13th July 2023

Ref : 23/01646/F - Single and two storey extensions and internal modifications to existing dwelling. Heyford Lodge, Heyford Road, Middleton Stoney, Bicester, OX25 4AL

Rev	
Project Heyford Lodge Park Farm Middleton Stoney	
Client J H Norman & Sons	
Drawing Proposed All Elevations	
Drawing No: 02/2023/05	
Issued for: Planning	
Date Mch 2023	Drawn by MCH
Scale(s) at A3size 1:100@A3

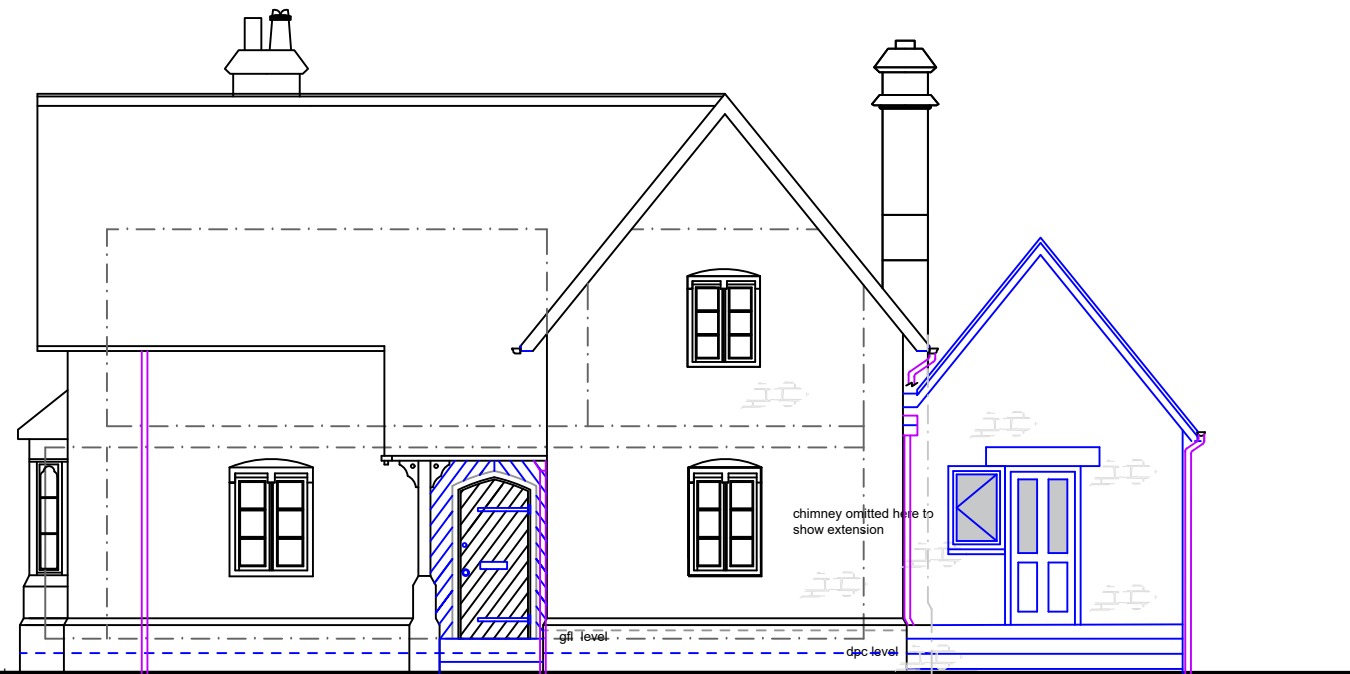
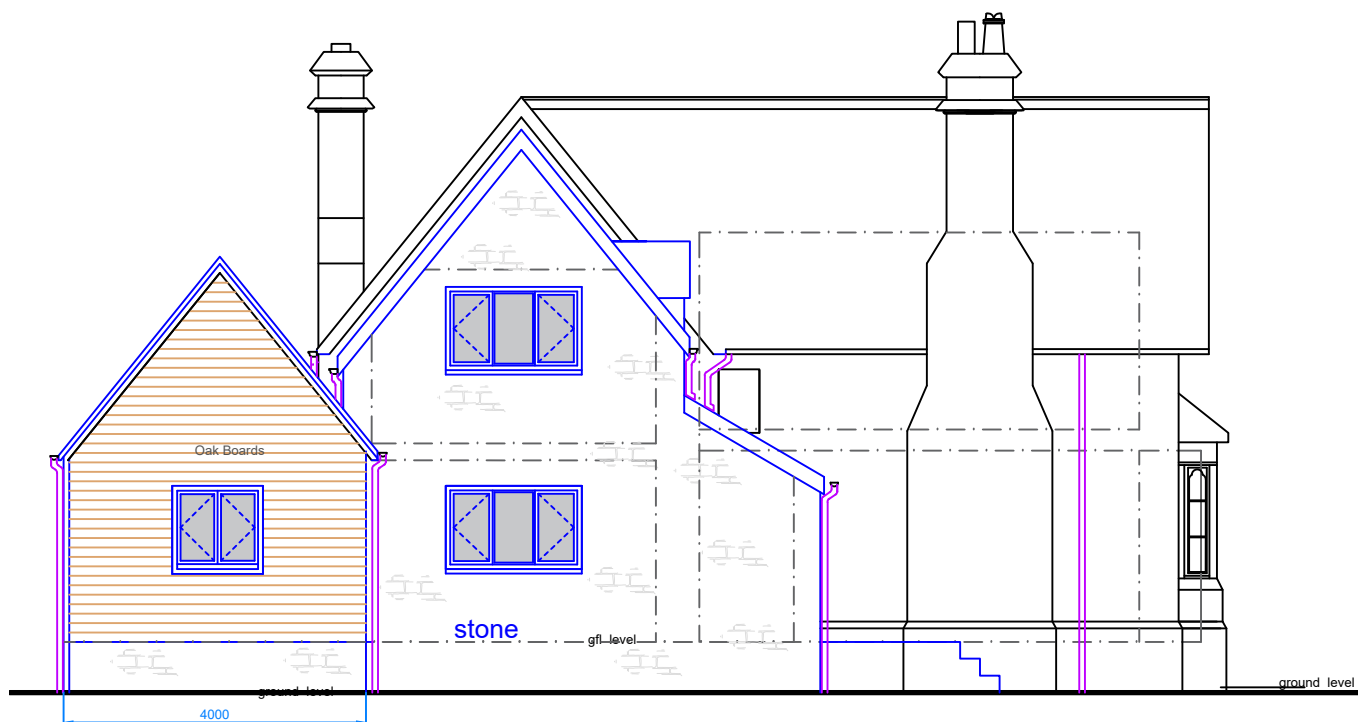
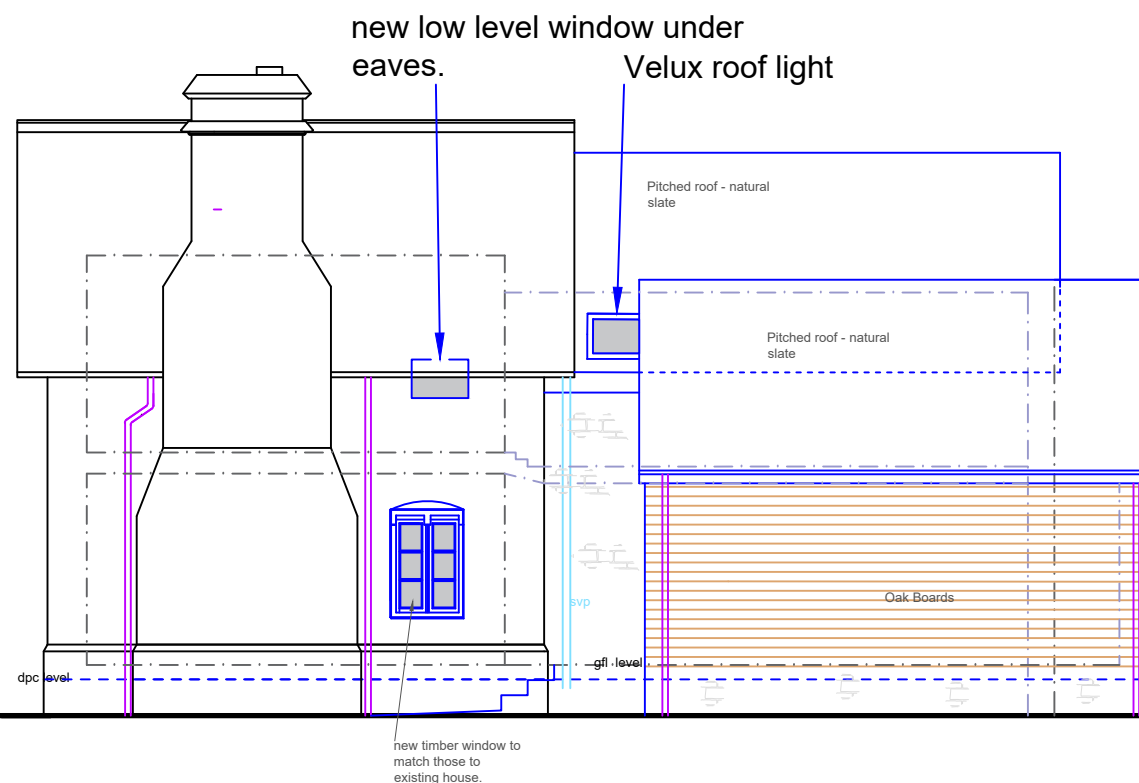
In our opinion, the single-storey extension is awkwardly related to the proposed two-storey extension and the fenestration could be more sympathetically designed. The lack of any reference to the RPG or other heritage assets means that insufficient information has been submitted in order for us to properly assess the application. We request that a proper heritage statement be prepared and that the design be reconsidered to simplify the fenestration and improve the relationship between the extension and the original lodge building.
